From: Andrew Strange [REDACTED]
Sent: 31 January 2019 21:12
To: Sian Eggington
Subject: RE: Parkside Farm - HOUSEHOLDER
Attachments: Location Plan 6a.PDF

From: Sian Eggington [REDACTED]
Sent: 31 January 2019 07:56
To: 'andy@ajsdesignsolutions.co.uk' [REDACTED]
Subject: Parkside Farm - HOUSEHOLDER

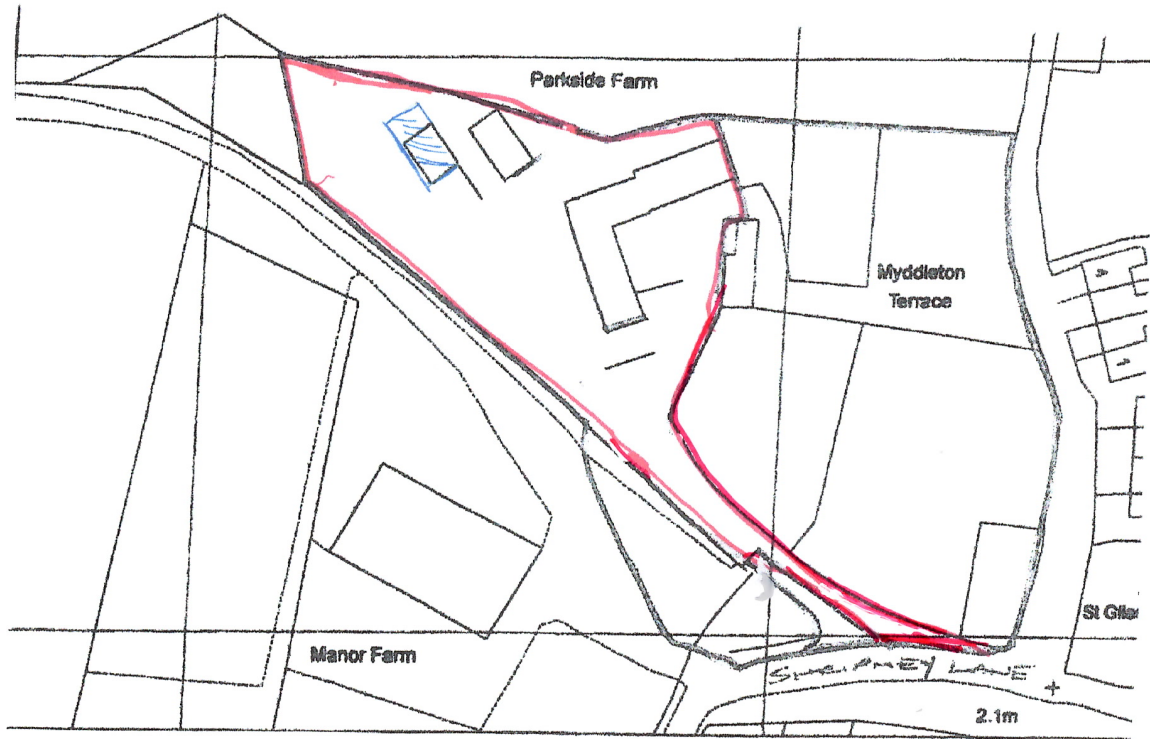
Thank you for your email all the plans are now fine however can you please join the red line on this location plan. I noticed you have done it on the block plan which is great however it needs to be done on this one too. Once I receive that ill make it valid and get that uploaded for you.

Please find attached amended plan as requested.
